CITY OF MERCER ISLAND

April 23, 2020

RE: Review Comments for File No. CAO19-01 Klein – Critical Area Review 2
74XX SE 38th St, Mercer Island, WA 98040; King County Tax Parcel # 362350-0226

CLEARING & TESC

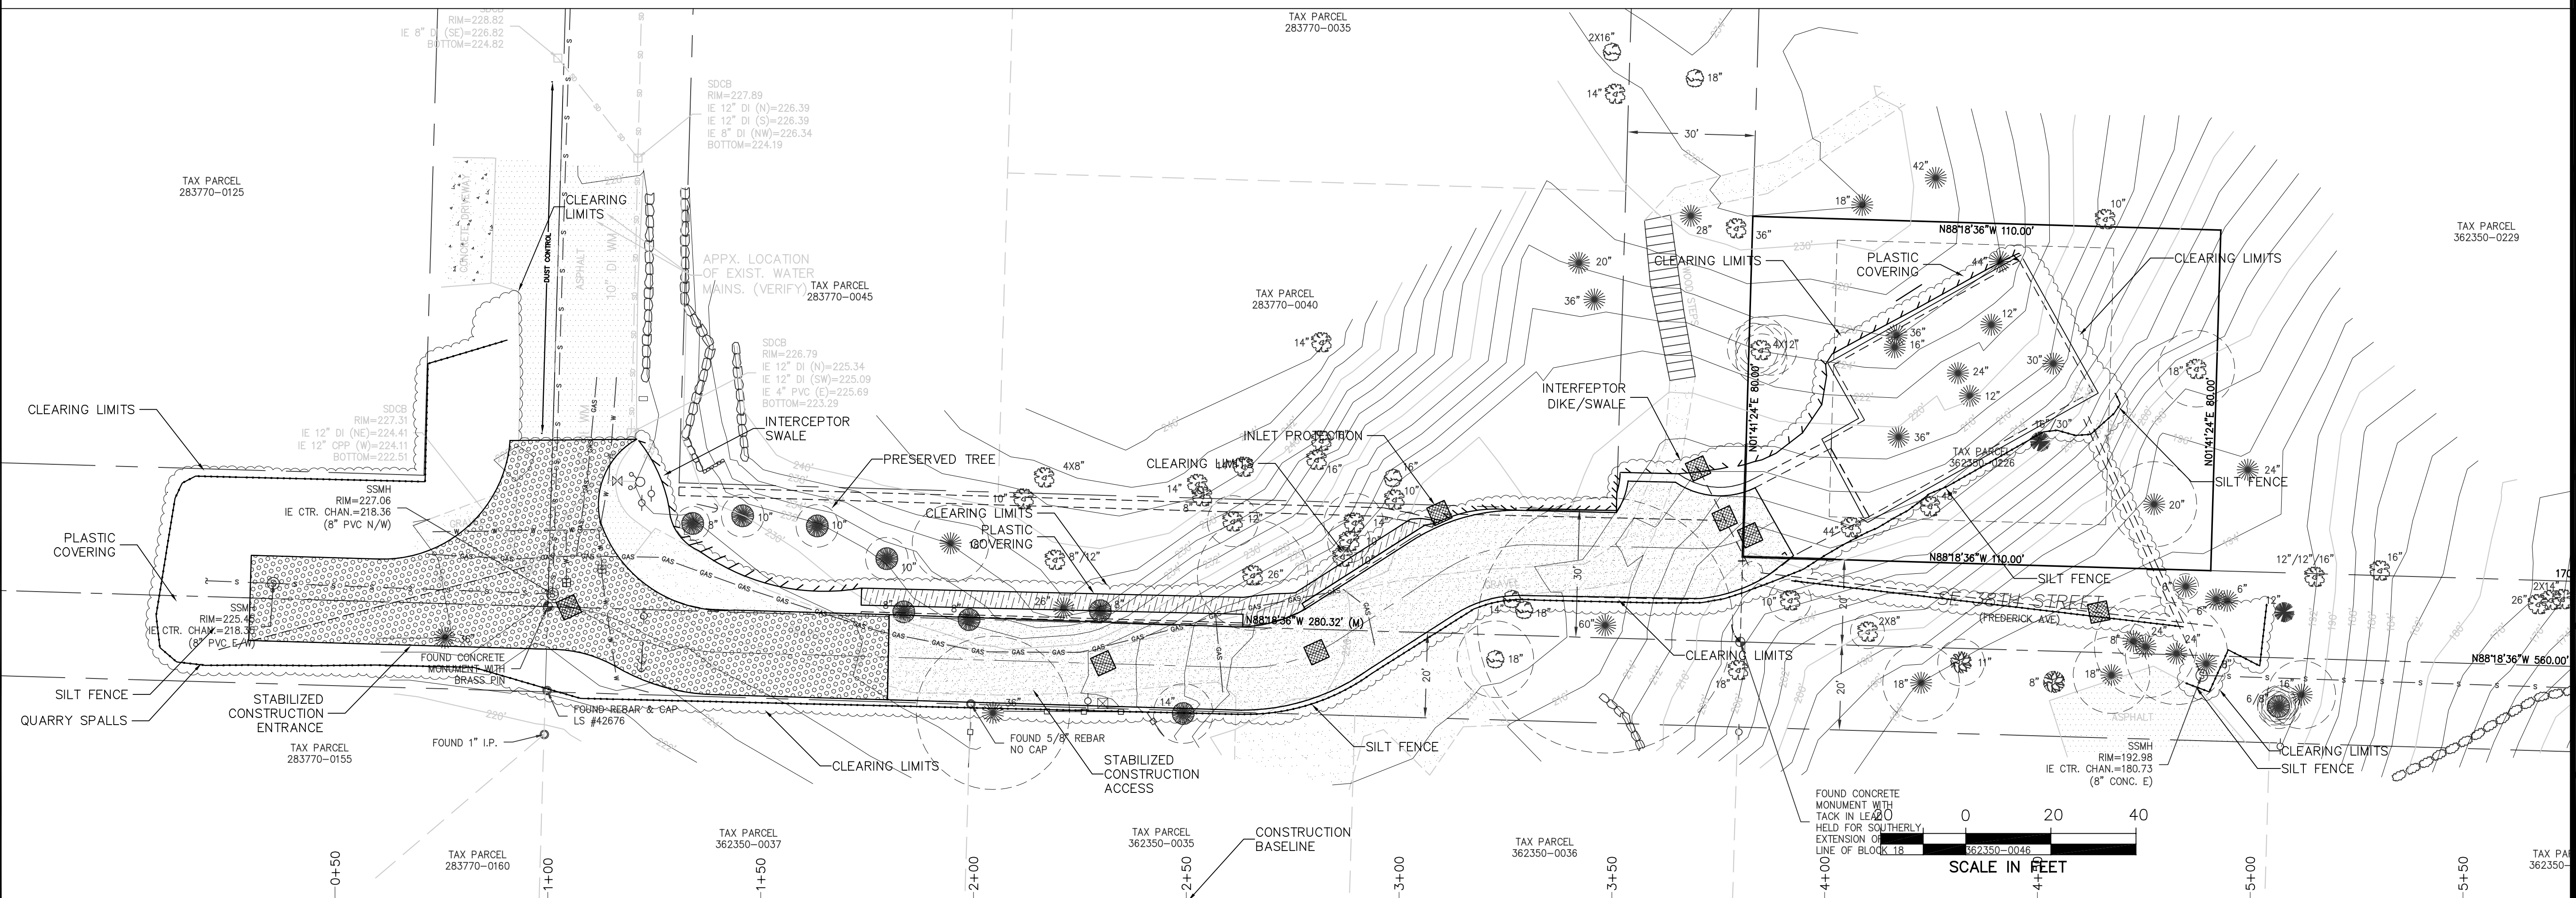
8. Show driplines of all trees according to Arborist report measurements.
9. Provide tree protection plan/direction from Arborist for all work proposed within saved trees driplines.

12. Tree Inventory Worksheet indicated 33% of existing trees to be retained. However, several trees have disturbance for foundation within limits of disturbance. These trees may have to be removed with the current plan. This would drop you below the required amount of 30% retained trees per MICC19.10.060.A.2.a.

13. Show on plans trees proposed for removal with an X through trees.
14. Identify Exceptional trees using different symbols for trees less than 24 inches and trees greater than or equal to 24 inches.

15. Limits of excavation near potential saved trees (e.g. excavation limits for building foundation). Air excavation should be used to determine limits of disturbance within saved trees driplines. This will be done under Certified Arborist supervision. And have Project Arborist follow up to determine final limits of disturbance. Or how close you can excavate/compact near saved trees. This shall be used near right of way trees and on site exceptional trees. This is very important since you are so close to the 30% threshold of required retained trees.

PAVING AND GRADING PLAN & PROFILE

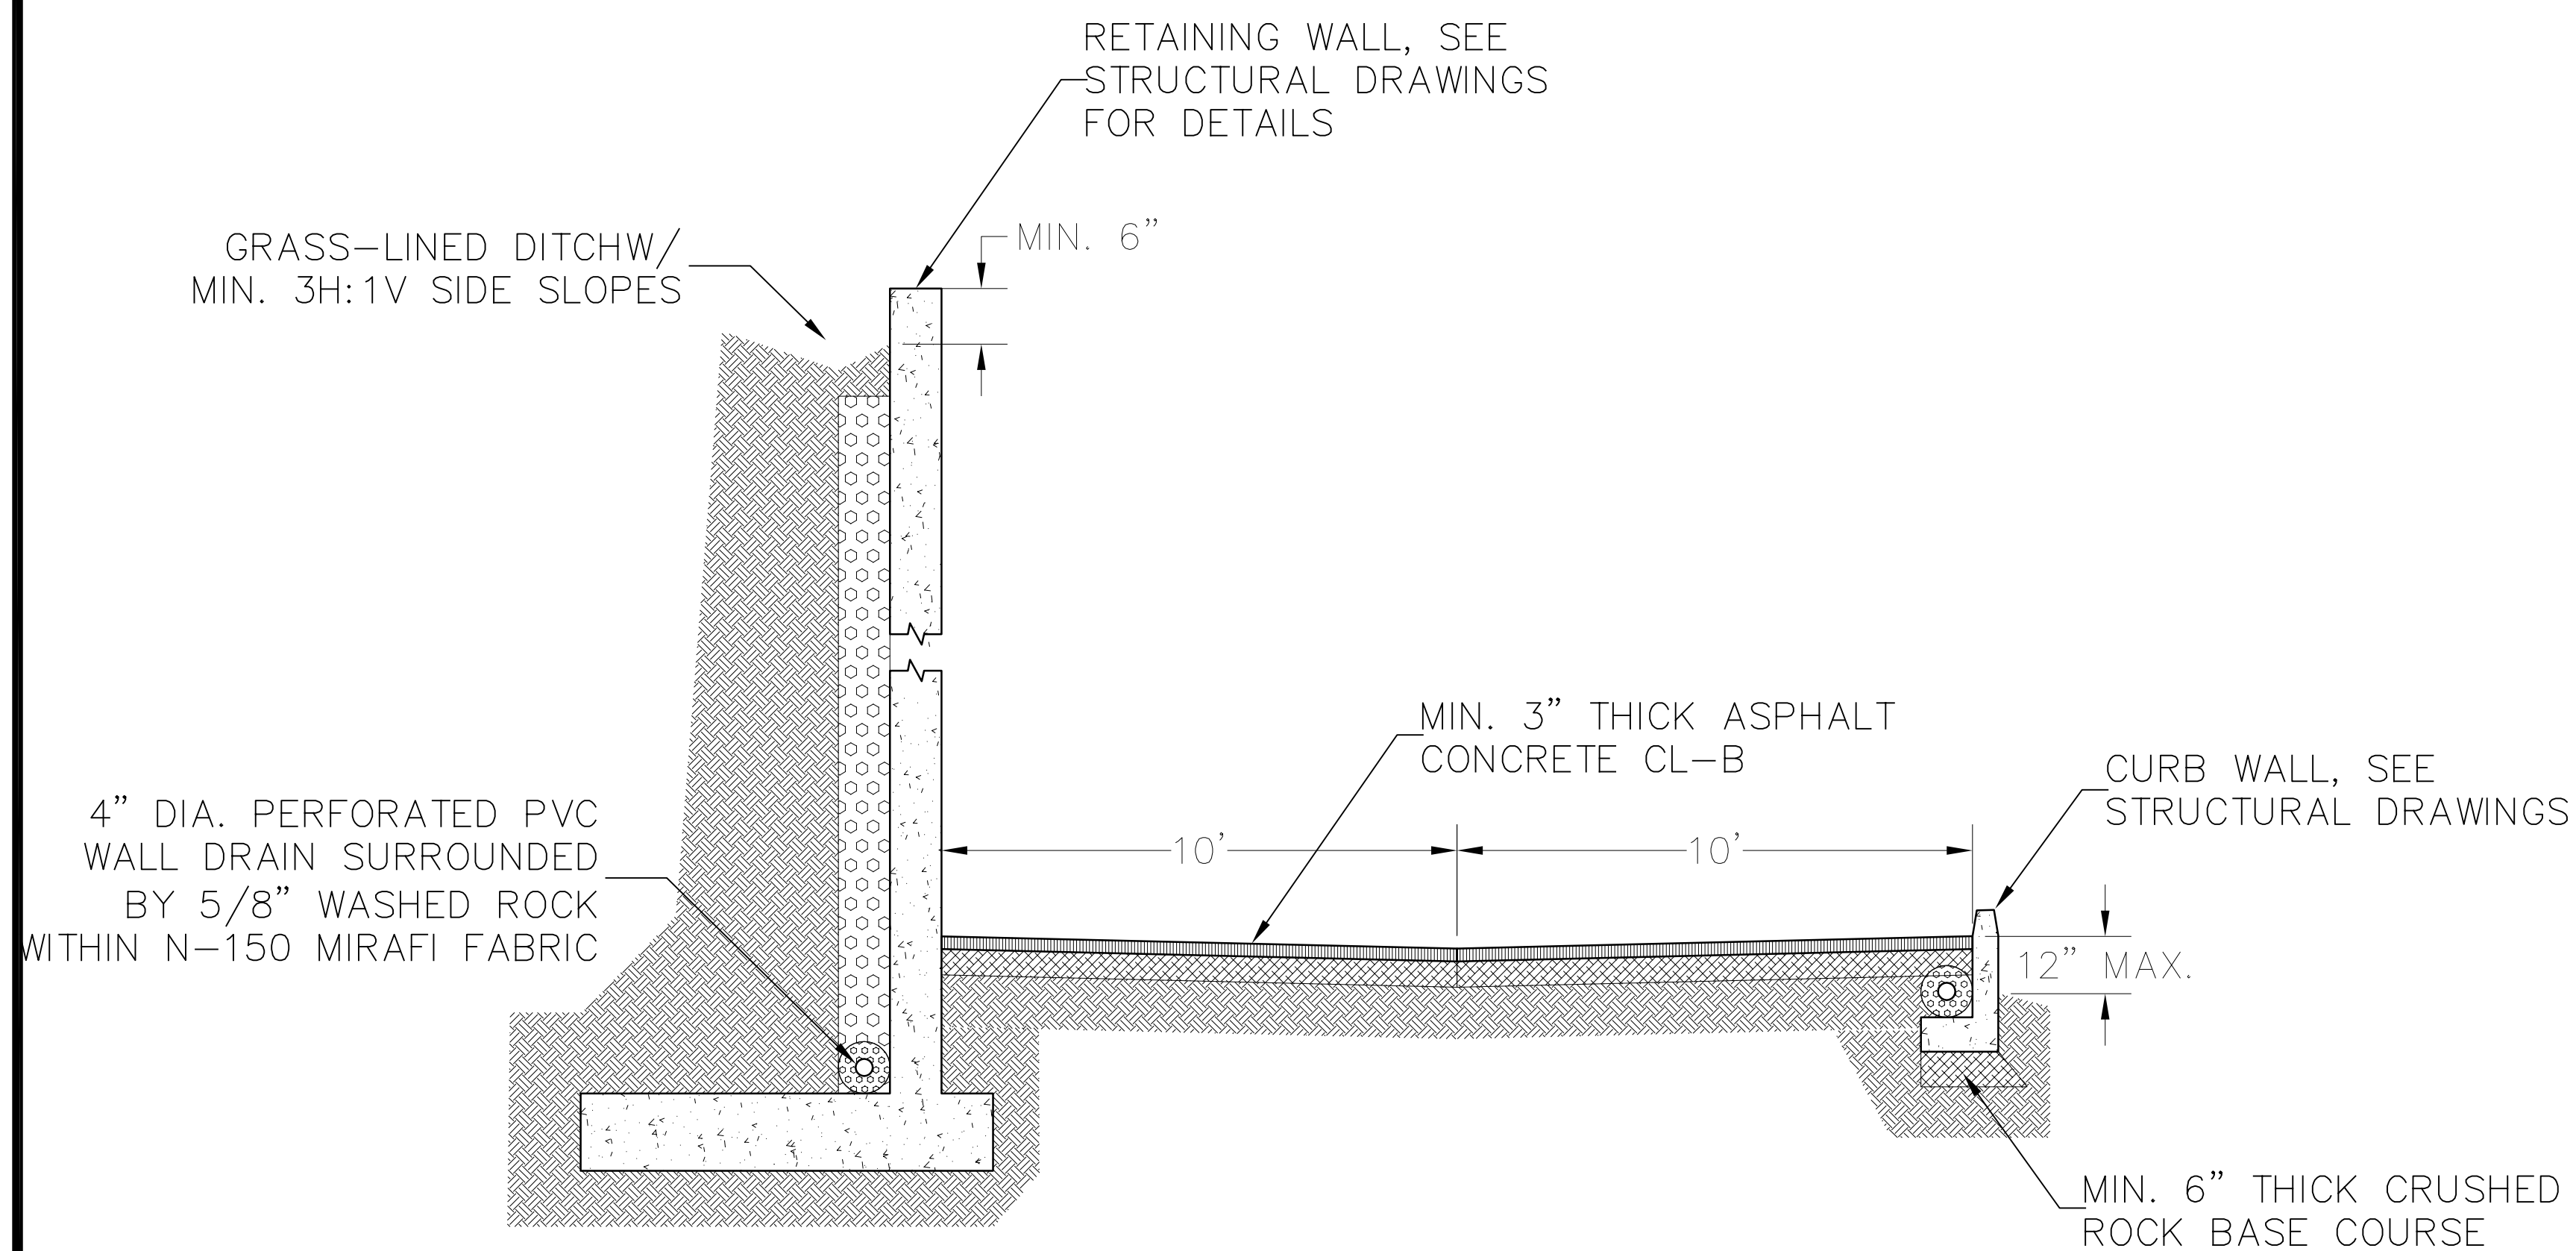
2. The public comments mention issues such as requests to narrow the road, preservation of exceptional trees and fruit bearing trees that provide a food source for wildlife, and the possibility of proposed retaining walls blocking access to a property. Please address these issues and provide a solution.

17. Driveway will need to meet minimum standards of 19.07 and IFC Fire access. If the fire access standards cannot be met code alternative requests will need to be made and approved in order to build. Information on code alt requests may be found on our website. Road design standards may be found under MI Code 19.09.040. Fire Access Road Standards may be found in the IFC or at our website. Fire Plan review for the residence will include access, grade, distance from a fire hydrant, available fire flow and turn-around access.
18. In addition to the above review comments, additional review comments have been provided on the project plans. Instructions for accessing and responding to these comments have been provided under separate cover.

UTILITIES PLAN & PROFILE

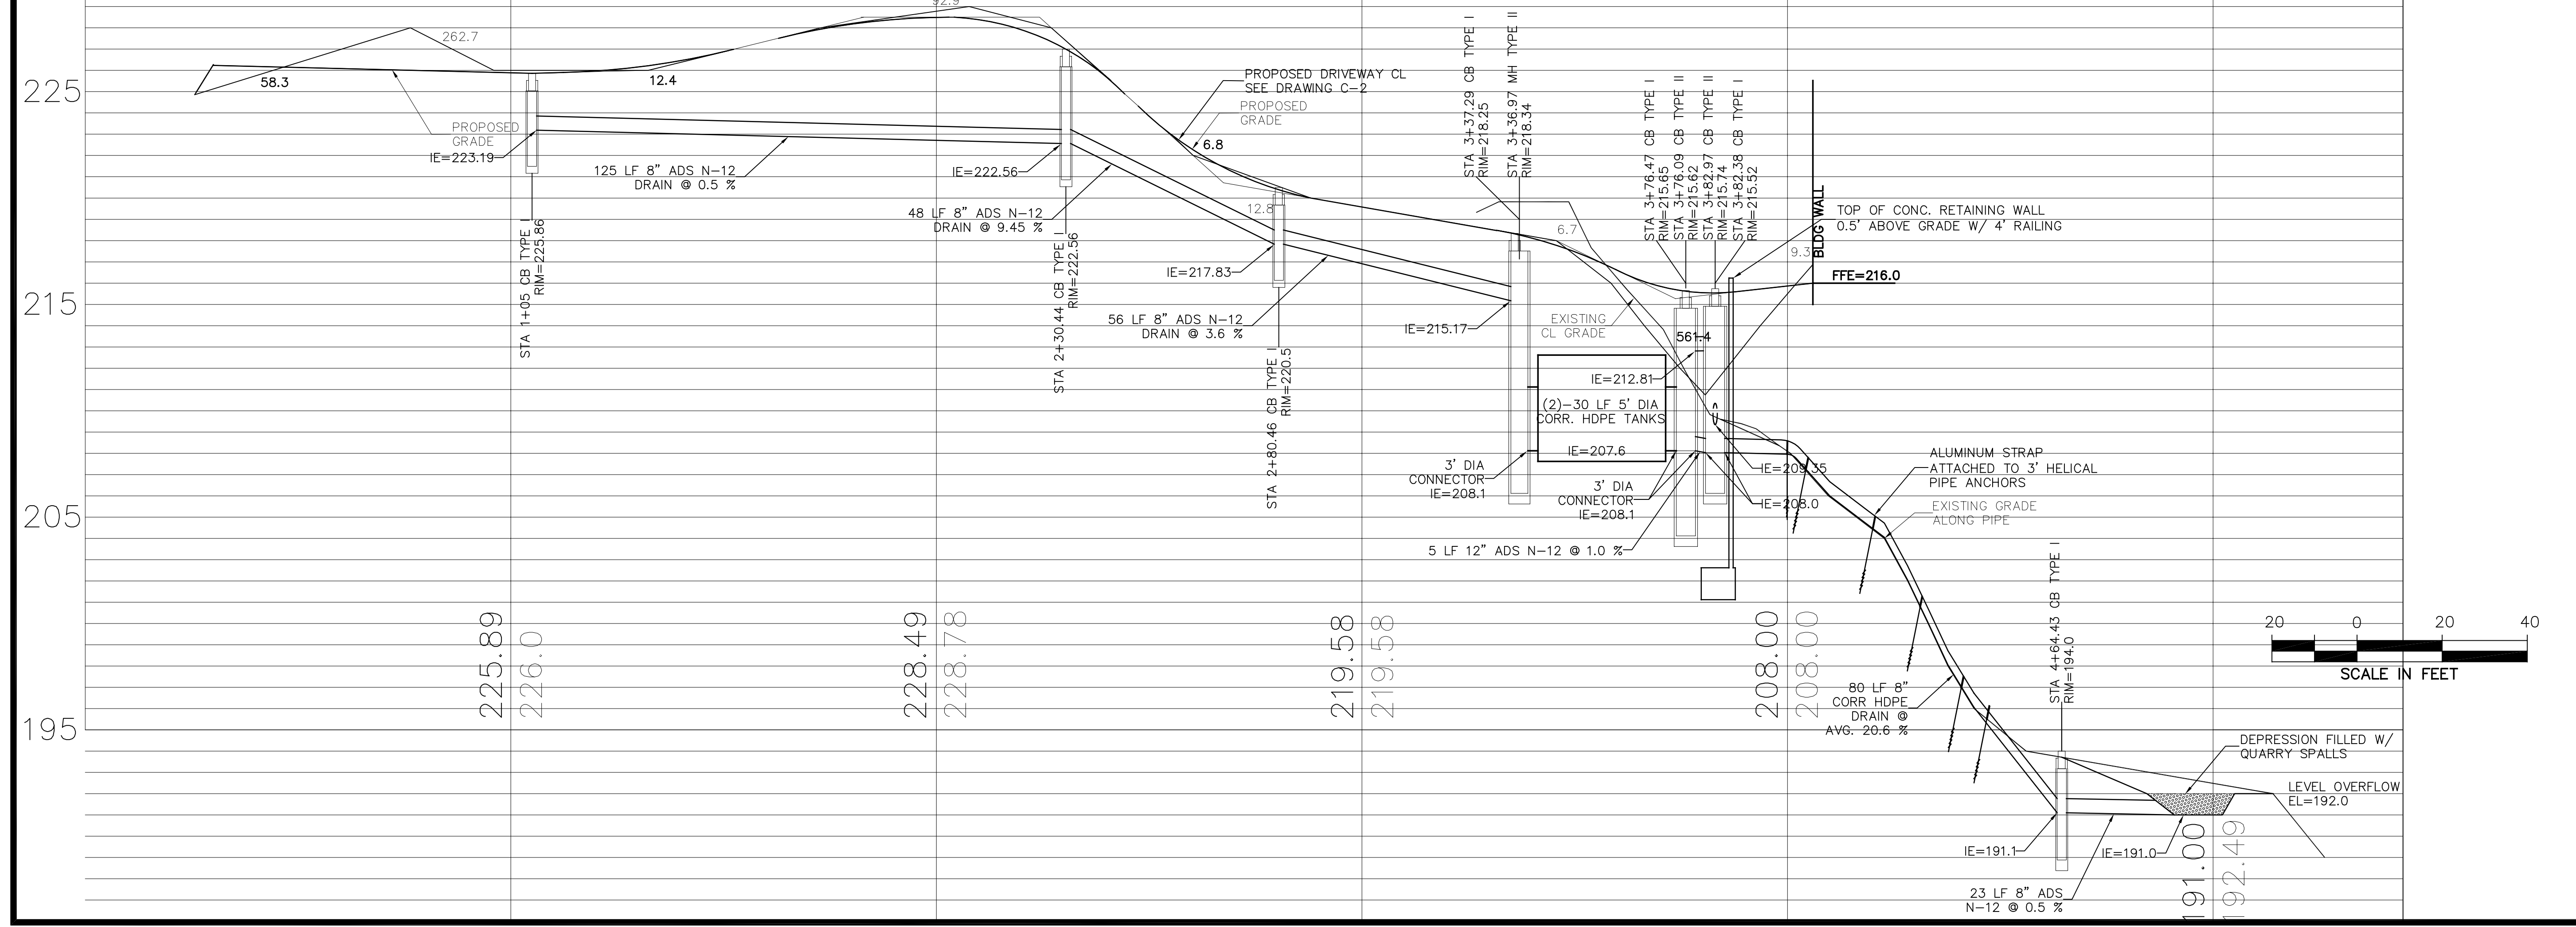
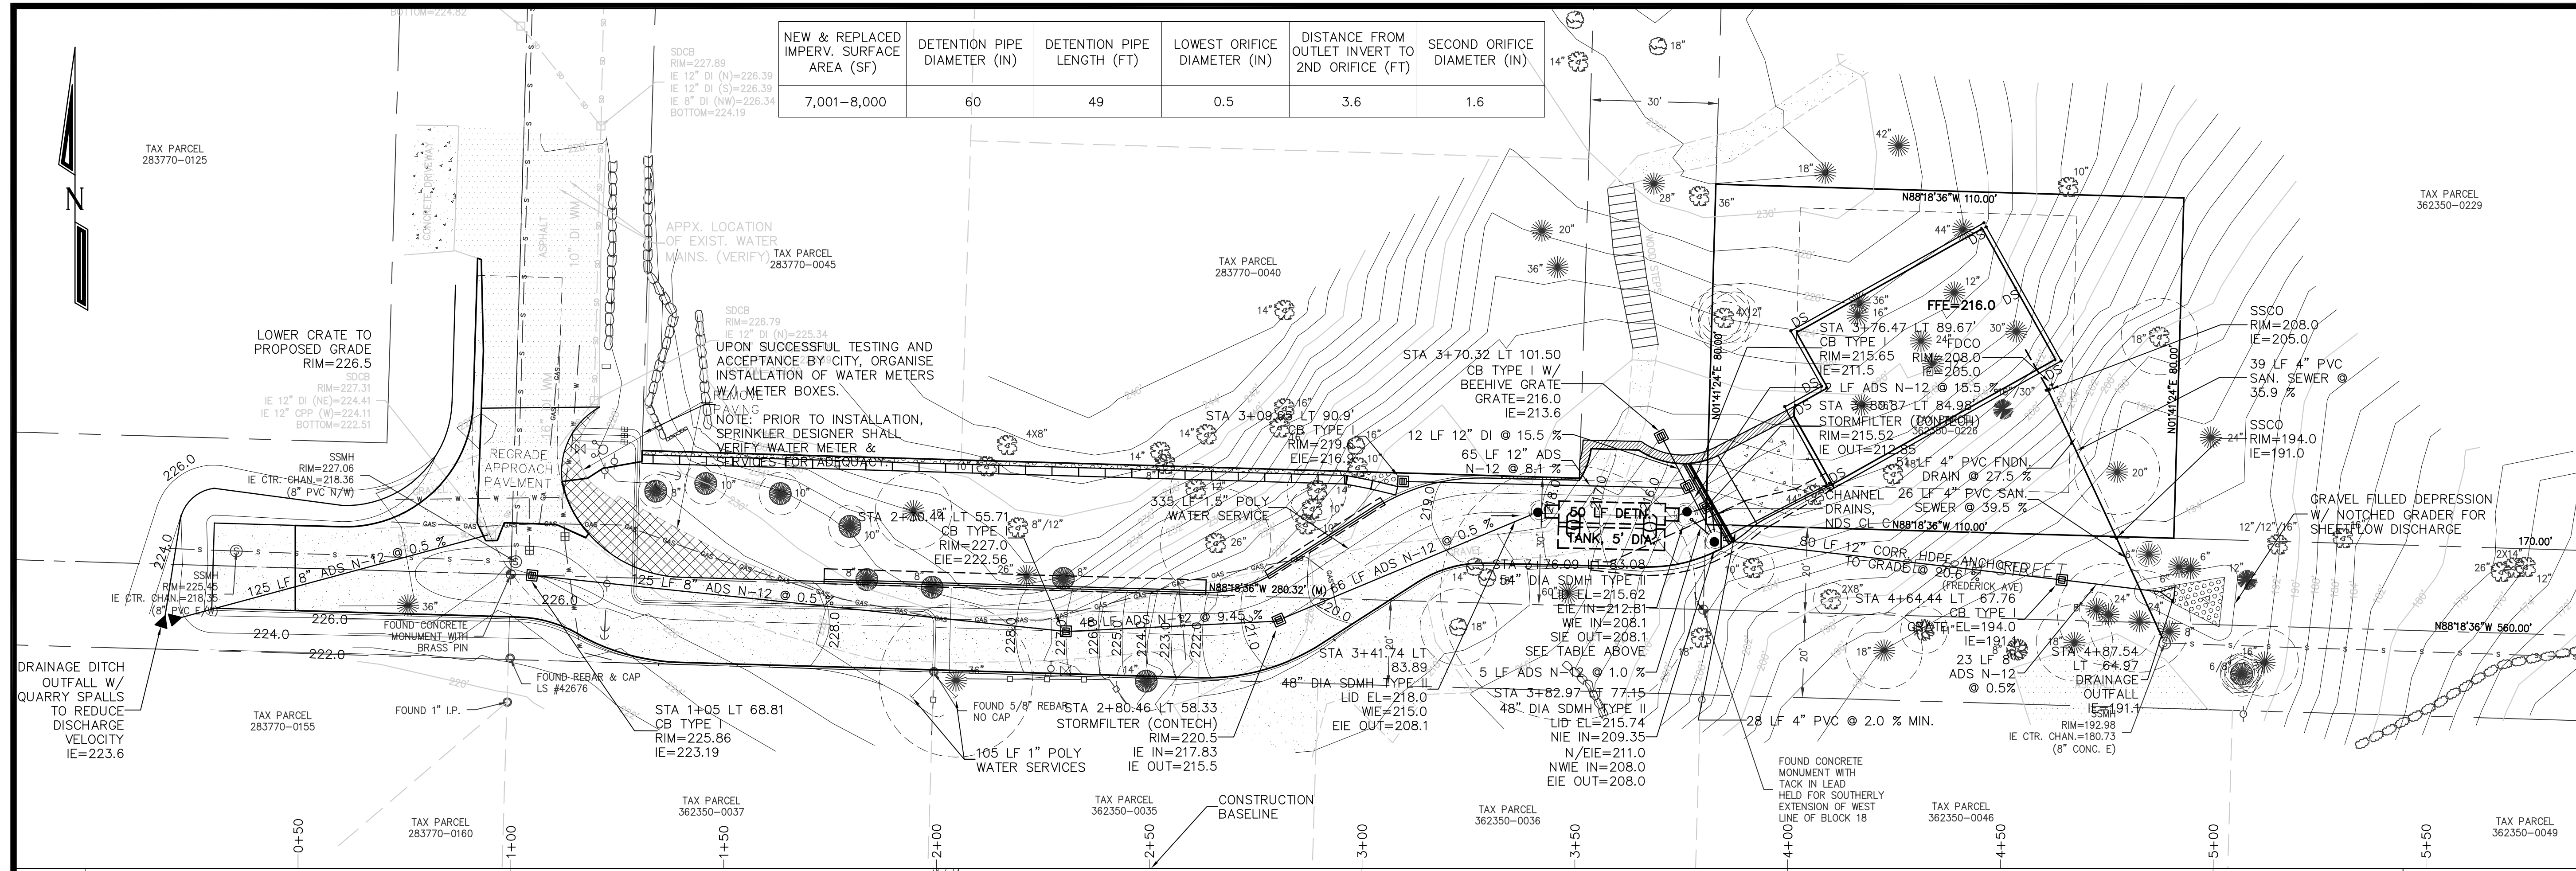
5. The plans currently show a stormwater system that uses dispersion. The City engineer reviewers have determined that dispersion will not be allowed, and that the stormwater systems must be

tightlined. The tightline infrastructure will likely be constructed within the vicinity of a watercourse and wetland and their associated buffers. Please expand the wetland and watercourse reconnaissance report to include all areas where off-site work will occur. Please provide a wetland and watercourse delineation. Please submit documentation as required by MICC 19.07.180 and MICC 19.07.190 for installation of said infrastructure. Please note that if the wetland is not an isolated Category IV wetland less than 4,000 square feet, and the wetland cannot be avoided, a Reasonable Use Exception may need to be obtained for this project.

10. Position catch basins and bore pits outside trees dripline. Call out bore/tunnel utilities within saved trees dripline when cannot be avoided.
11. Show tree protection at limits of disturbance or driplines from Arborist Report.
